From: Jean Fraser
To: angel.robinson@guggenheimpartners.com; dfenstermacher@vhb.com
Date: 2/16/2016 2:38 PM
Subject: Re: Taco Bell at 1363 Washington Avenue
Attachments: 2016.02.15 Washington Ave Peer Review Memo.pdf

I attach the comments of the Peer Engineer Reviewer from Woodard & Curran (they focus on site stormwater and utilities). I would be grateful if you could also address or respond to these comments.

*Jean Fraser, Planner
City of Portland
874 8728*

Not Approved for Construction
Drawing Title
Layout & Materials

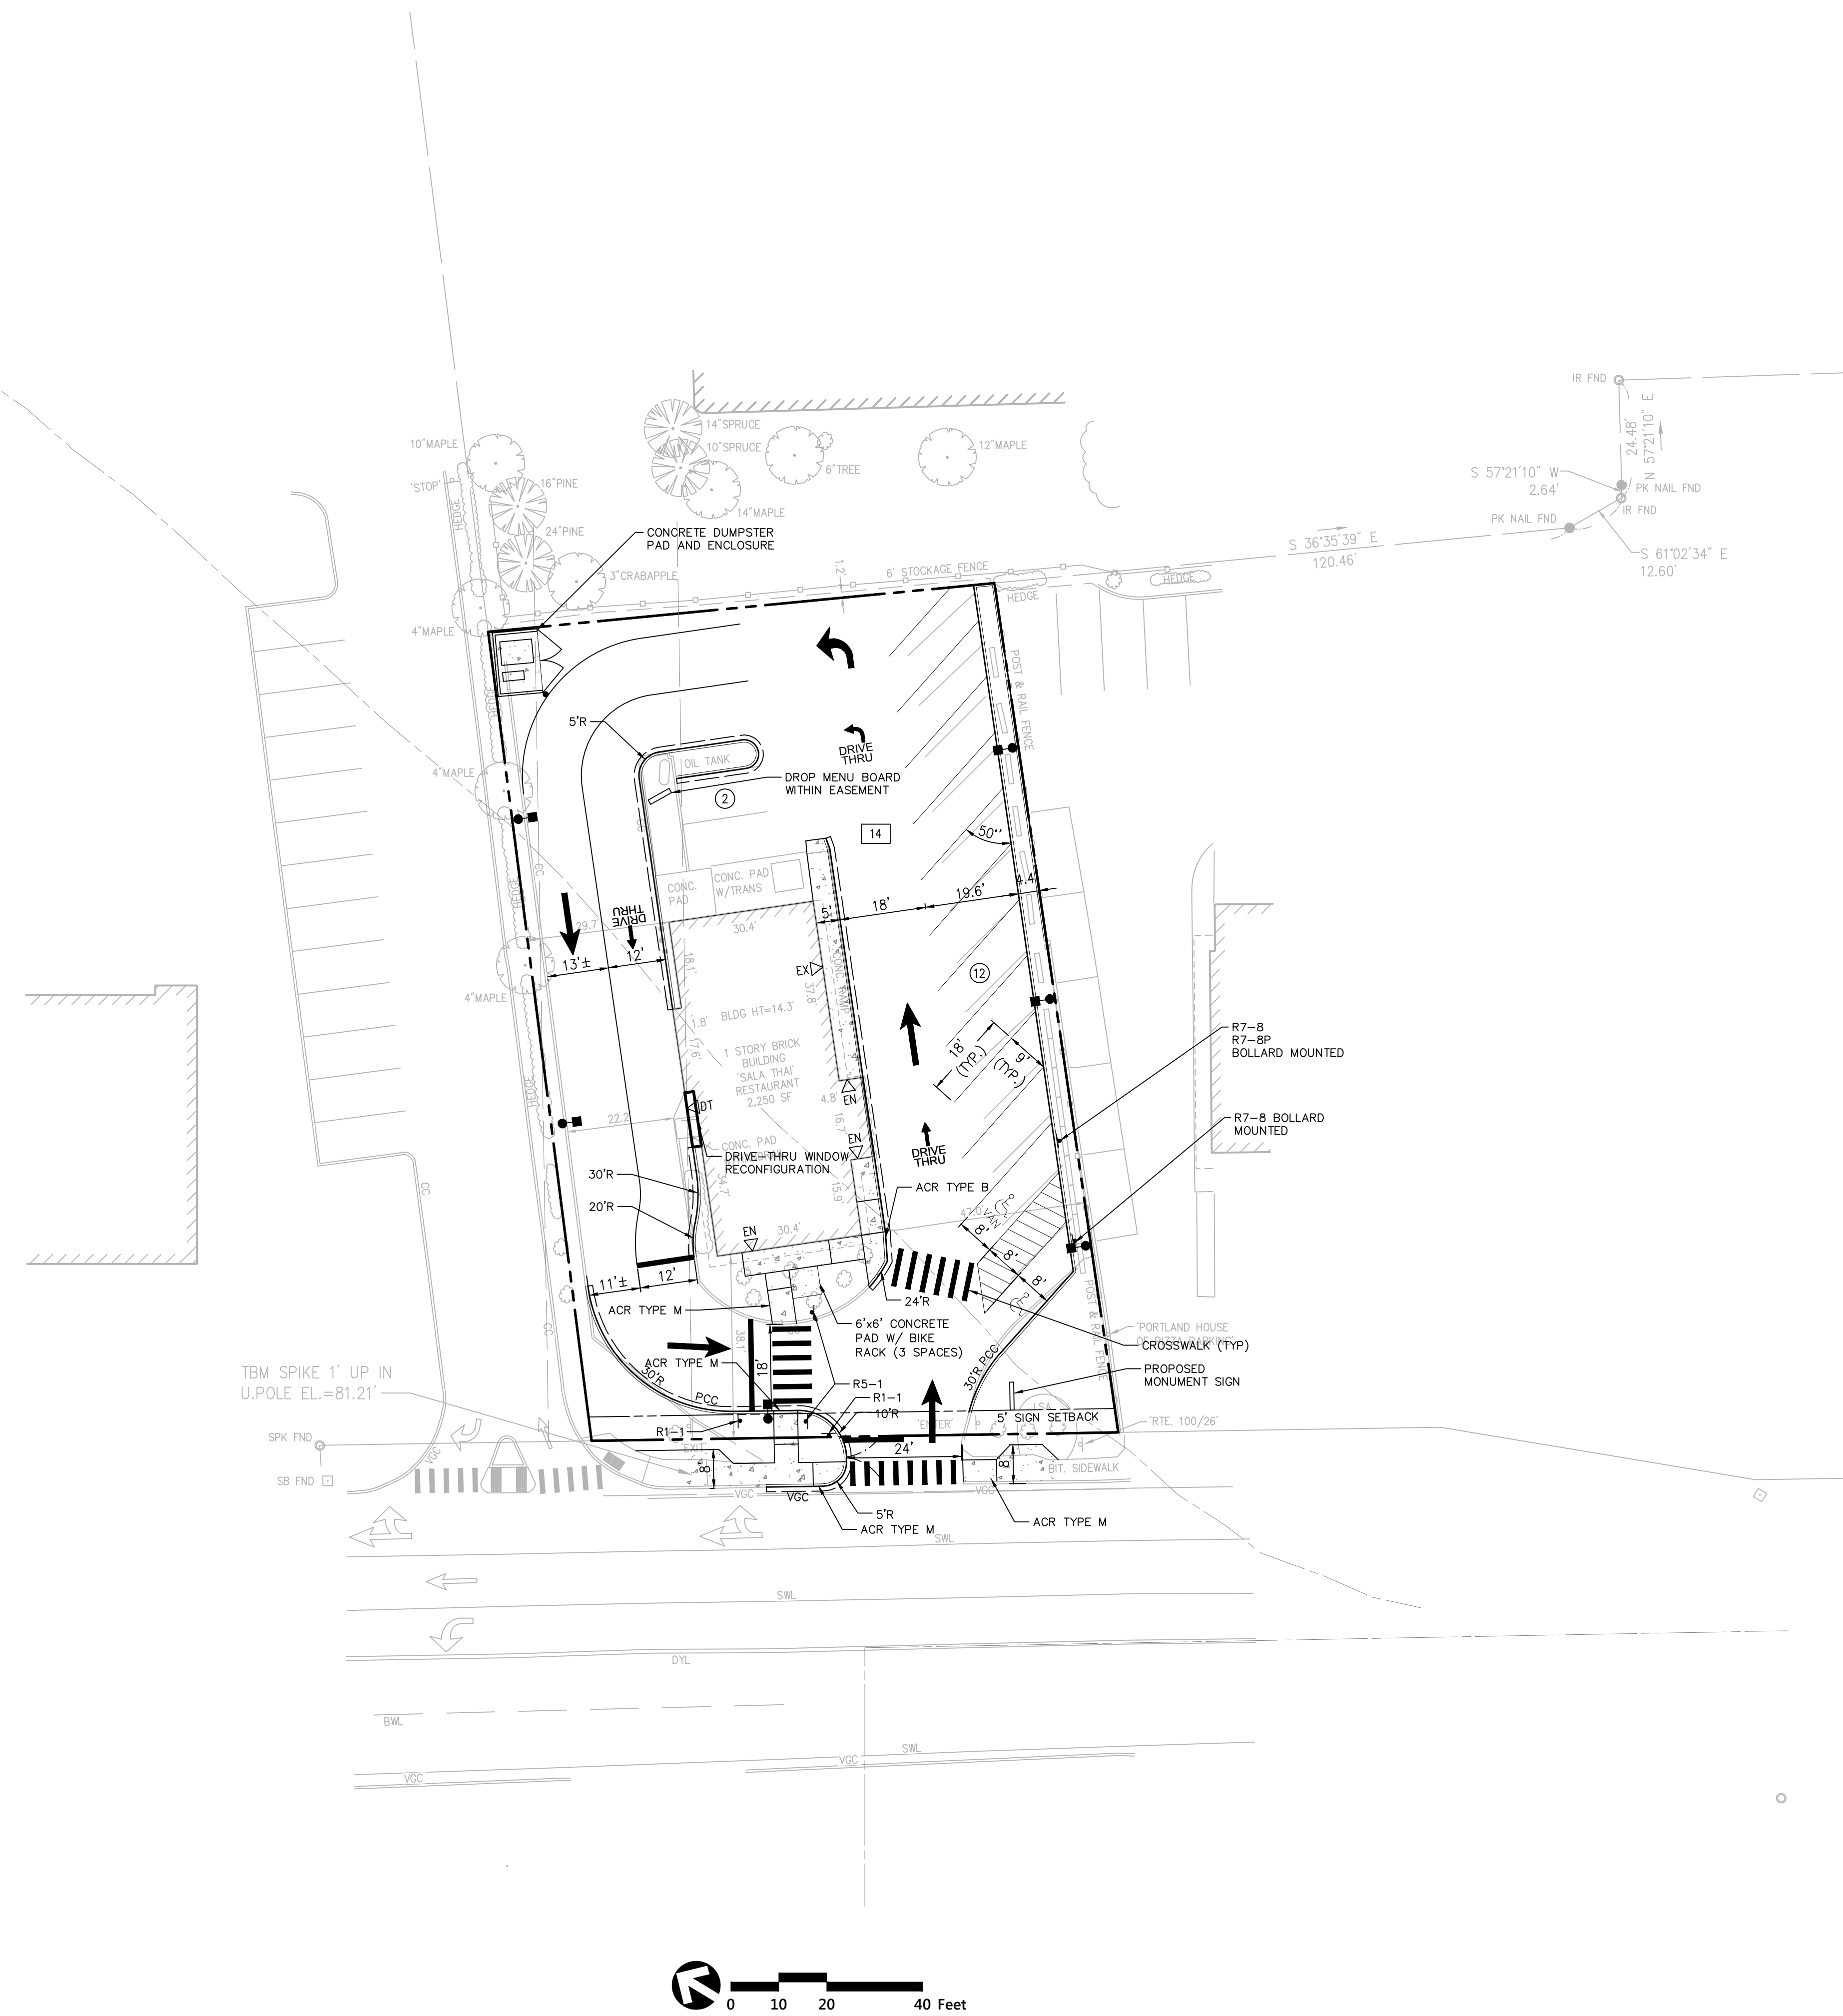
Zoning: Please provide the before and after impervious surface areas and the calculation of the % of the site that is impervious. The Zoning requires this to be 80% maximum and it looks like the site is around 90%. You need to reduce the non-conformance as far as possible and there are opportunities on the site to create more pervious areas. Also under zoning is the requirement (see under Dimensional Requirements 14-185 footnote) for trees and a 4 foot wide planted area along the frontage. This will be interpreted with flexibility as this is an existing site and there are other factors.

Landscaping and B2 Design Standards re screening: the entire site is subject to landscape and screening standards and there are also street tree requirements - please see 14-526 (b)2 b *Environmental Quality Standards* (attached) and the *B2 Design Standards* para 8 (attached). There is also guidance in the City's Technical Manual (Section 4) which is on the Website at <http://www.portlandmaine.gov/documentcenter/view/2211> The City Arborist will be reviewing the plan and may suggest specific improvements, but I think this might need to wait until the access question is resolved. In any case the dumpster would need to be enclosed and parking lot landscaping be enhanced; snow storage areas should be identified.

The two way full access drive as proposed is not safe and another approach needs to be incorporated. Our preferred option is to utilize the Rite Aid access drive that runs along the side of the site. If that is

not feasible, then a right-in right-out restriction at the drive entrance on Washington would be required. The sidewalk along this frontage needs to be widened so that it extends to the site property line along the entire frontage. This is so that it is safe in the context of the more intense level of traffic proposed. This would be the applicant's responsibility as per our ordinance. I will forward the written comments as soon as they are received.

Not Approved for Construction
Drawing Title
Utility Plan
Drawing Number

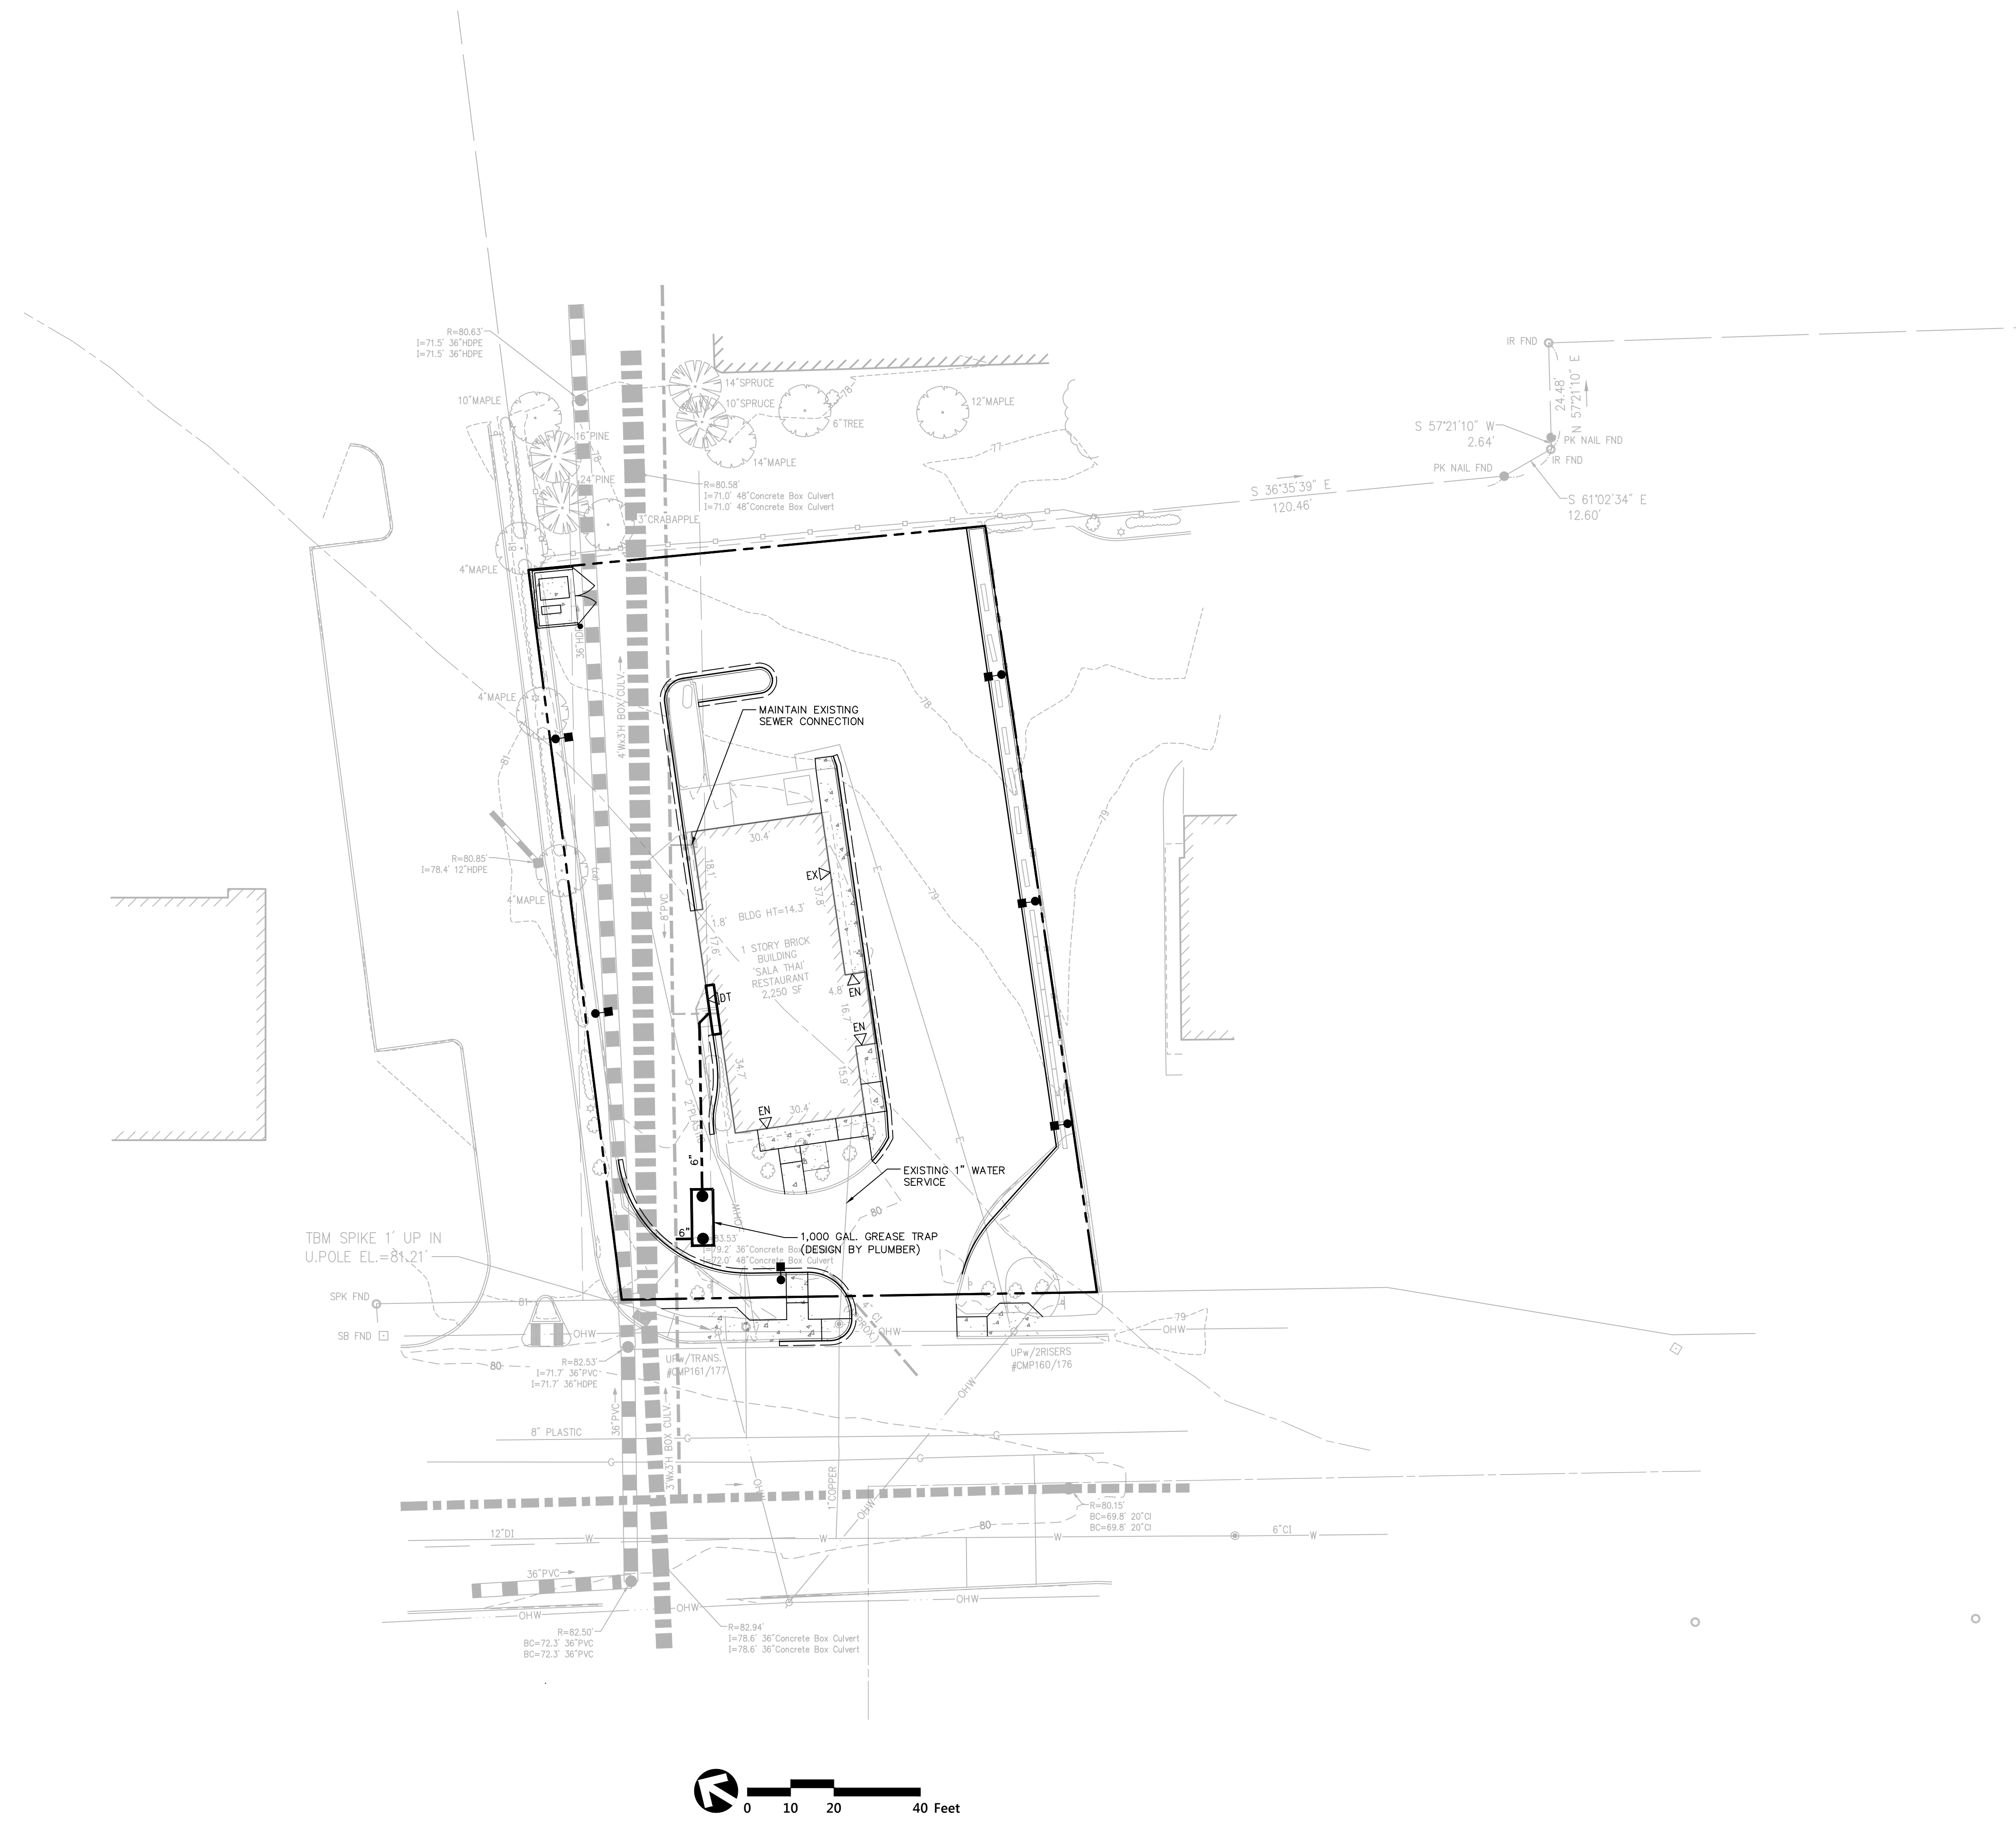
Sewer and ROW: Please see DPW comments attached.
